CITY OF ALBUQUERQUE

**Re: Peak Motion, 7424 Holly Ave., Grading and Drainage Plan
Engineer's Stamp Dated 12-12-2012 (C-19/D057)**

C101

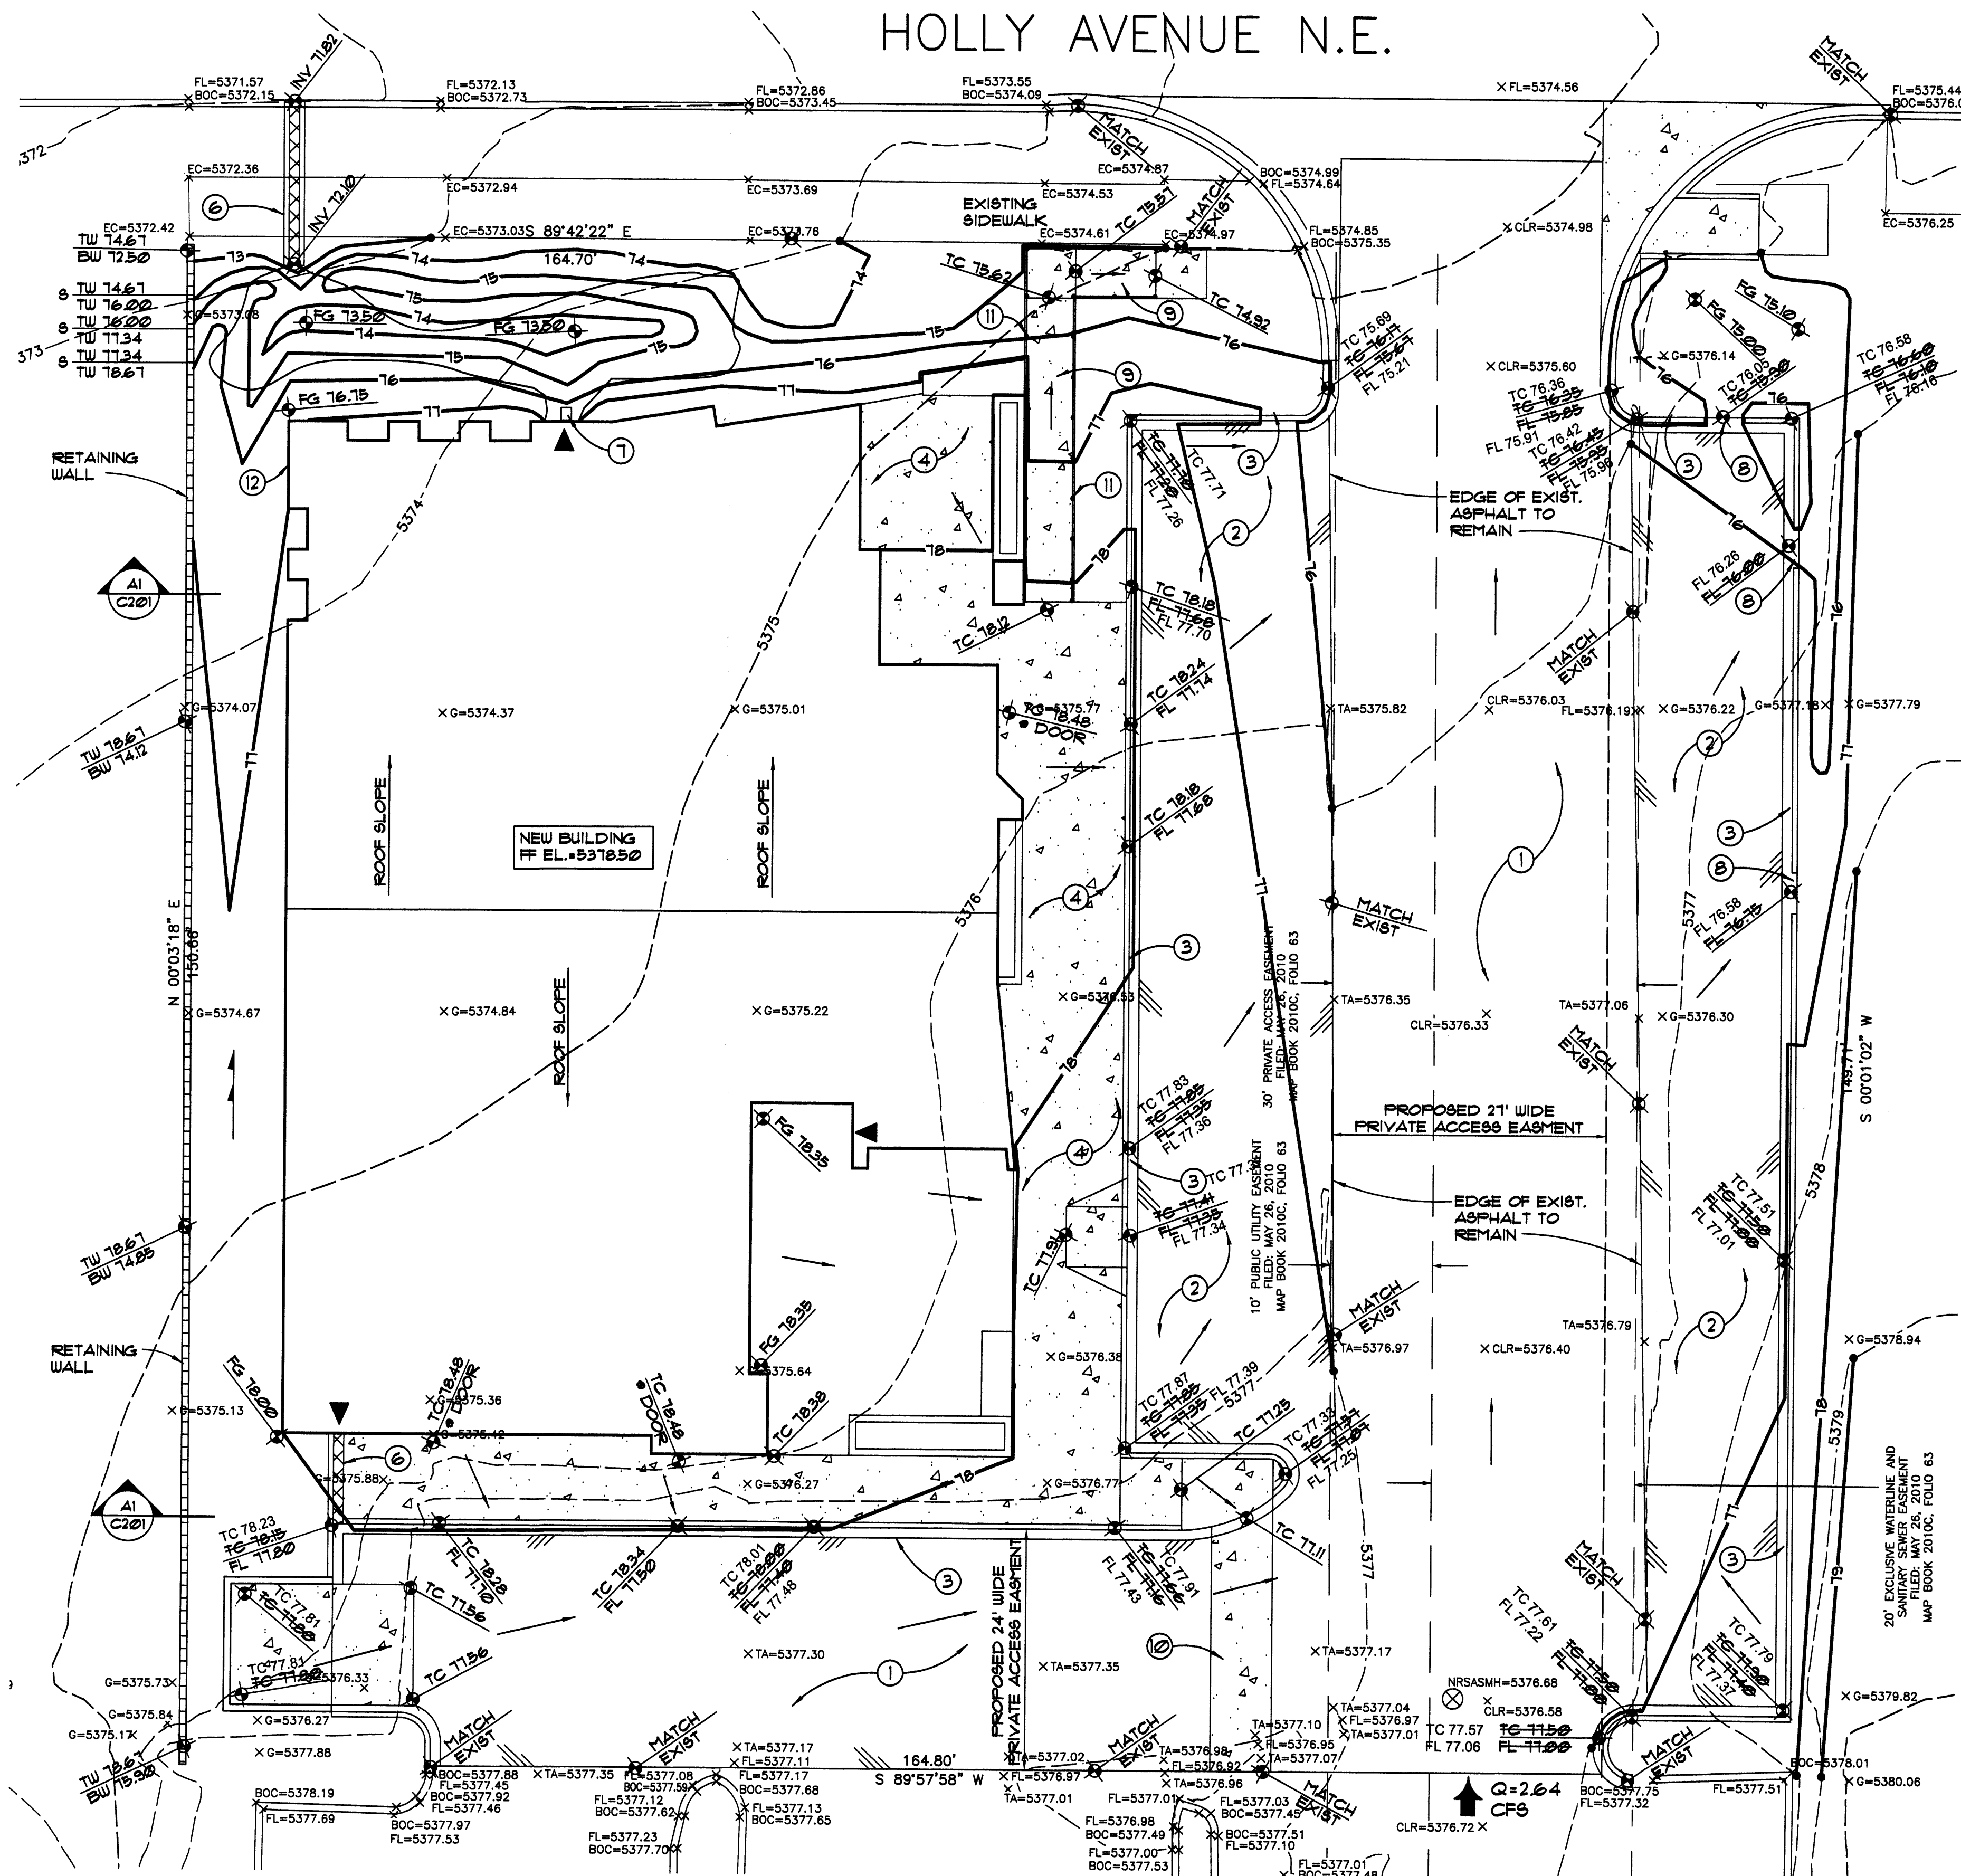
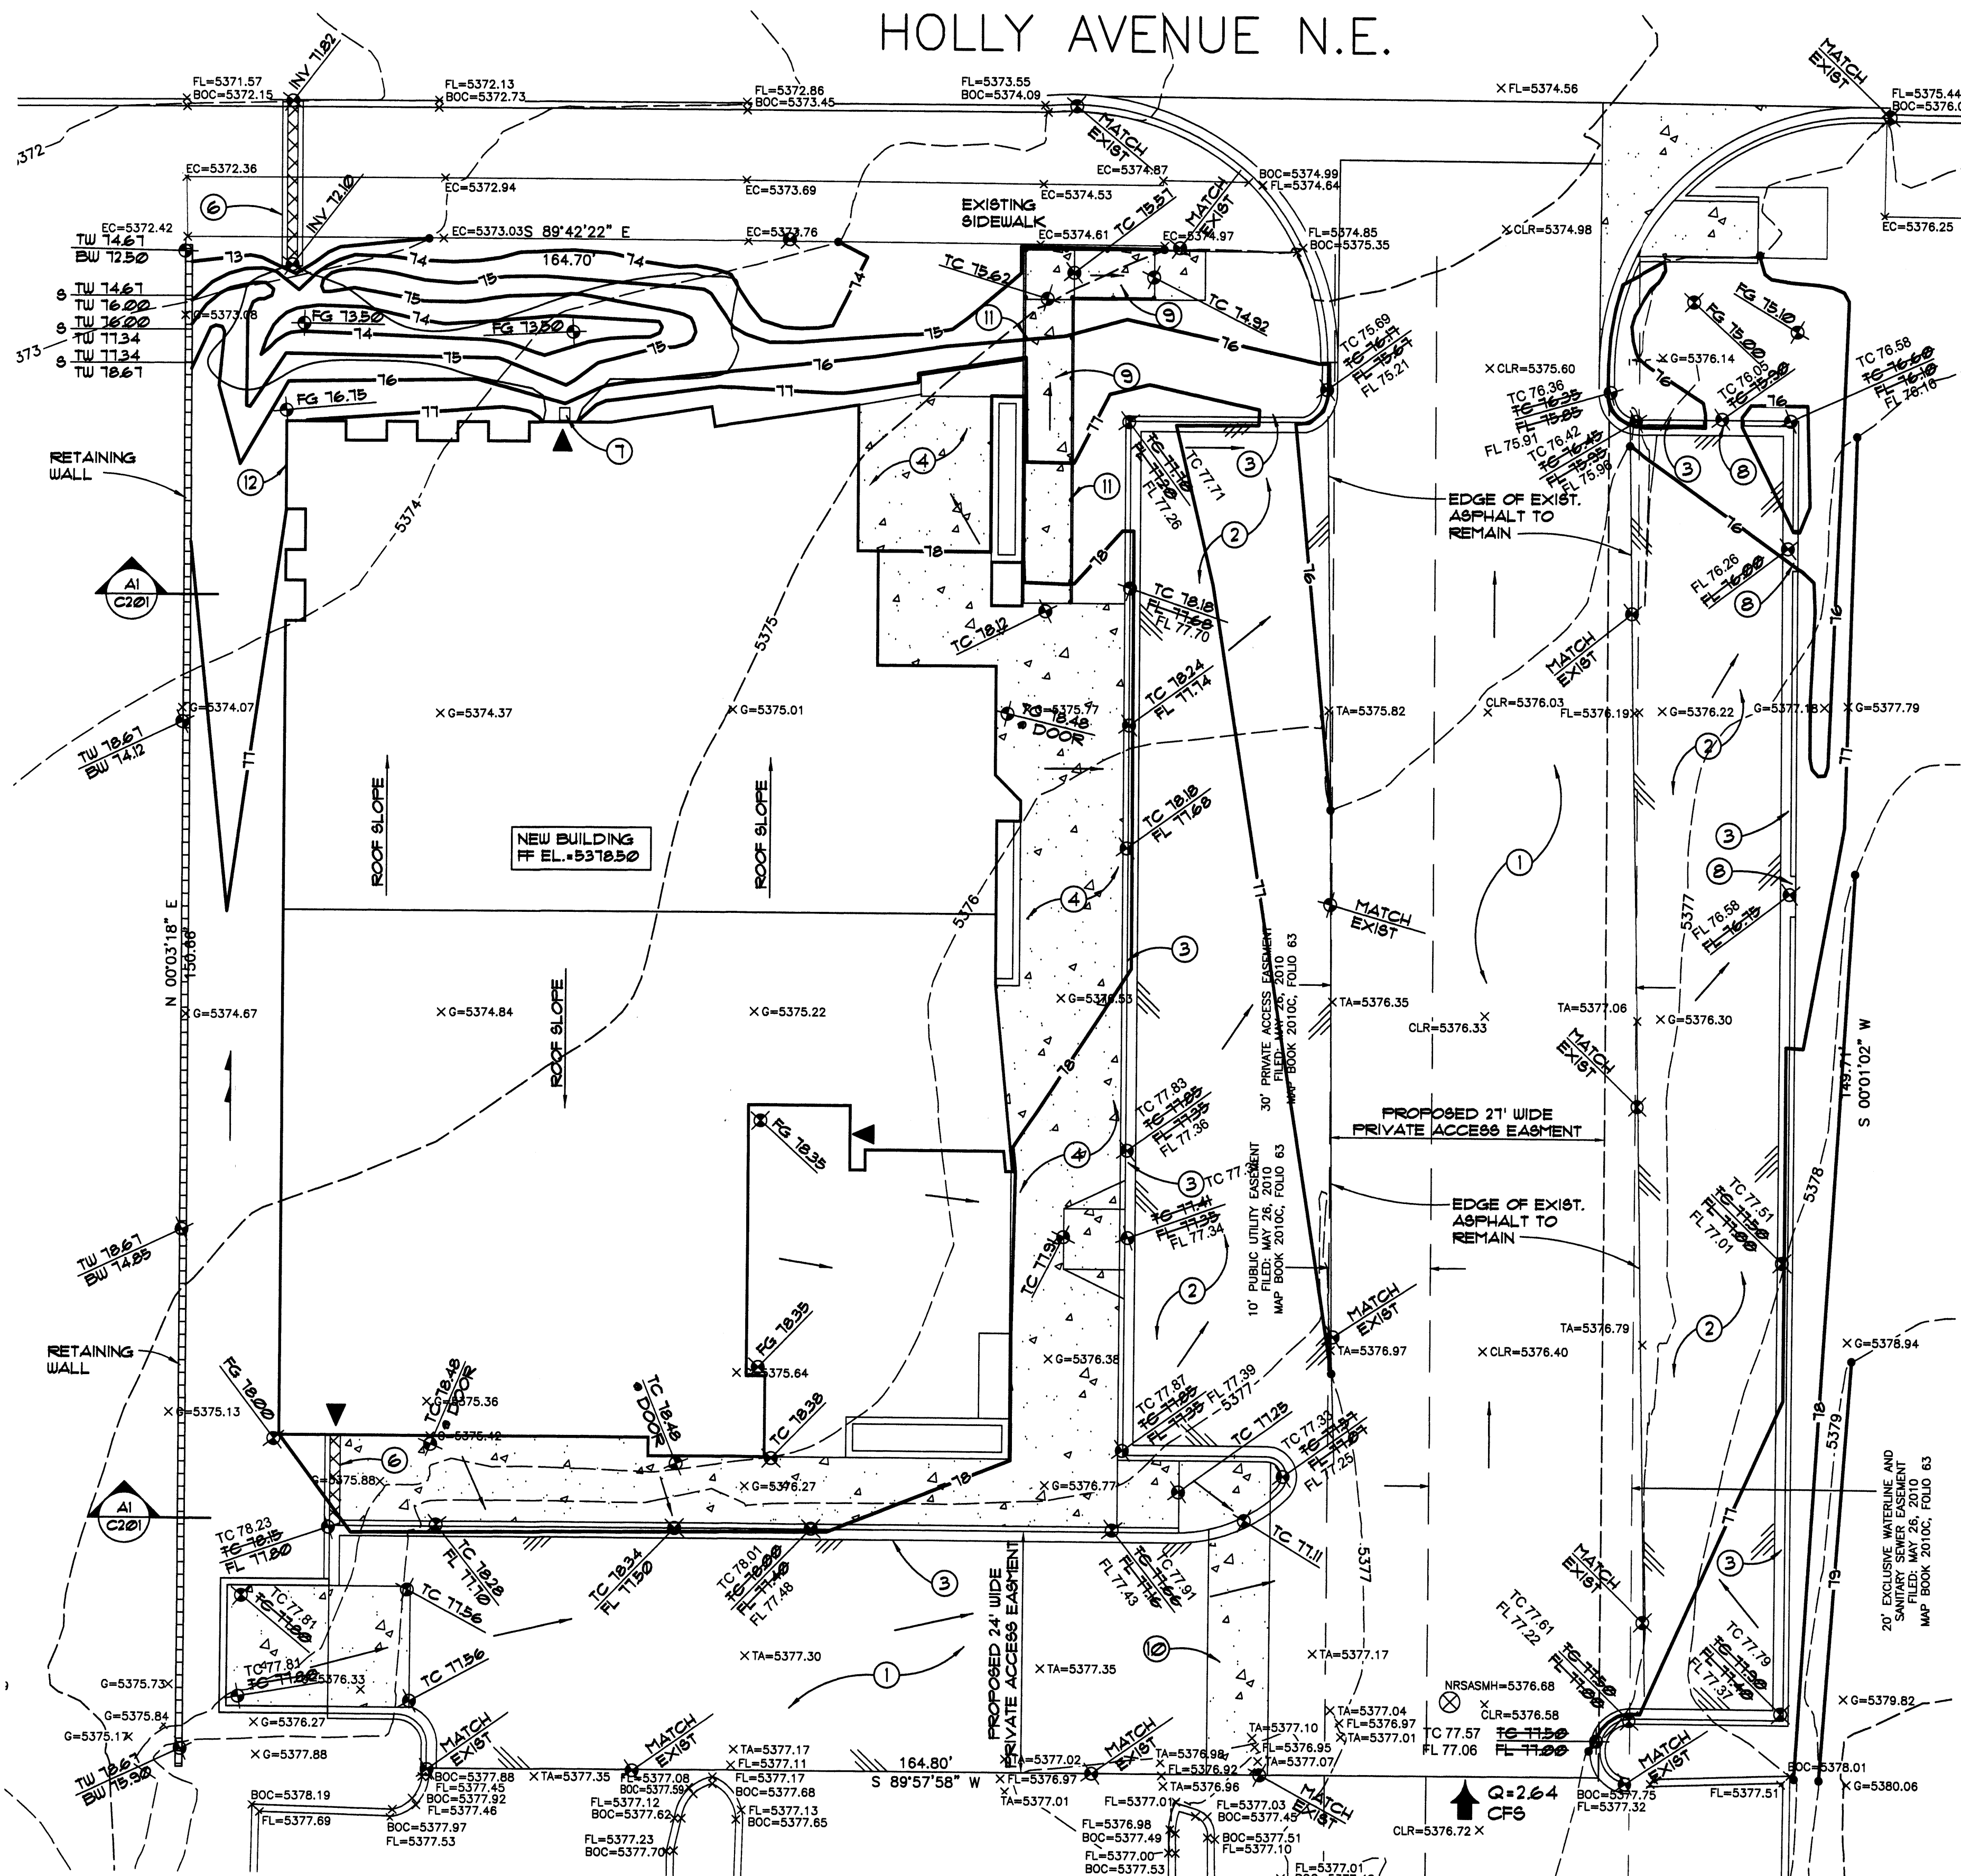
Based upon the information provided in your submittal received 12-12-2012, the above referenced grading plan is approved for Building Permit with the removal of Note #5 and corrections to the benchmark designation made and initialed by yourself. The sidewalk culvert along Holly Ave. is still expected to have a 2' extension from the back of sidewalk.
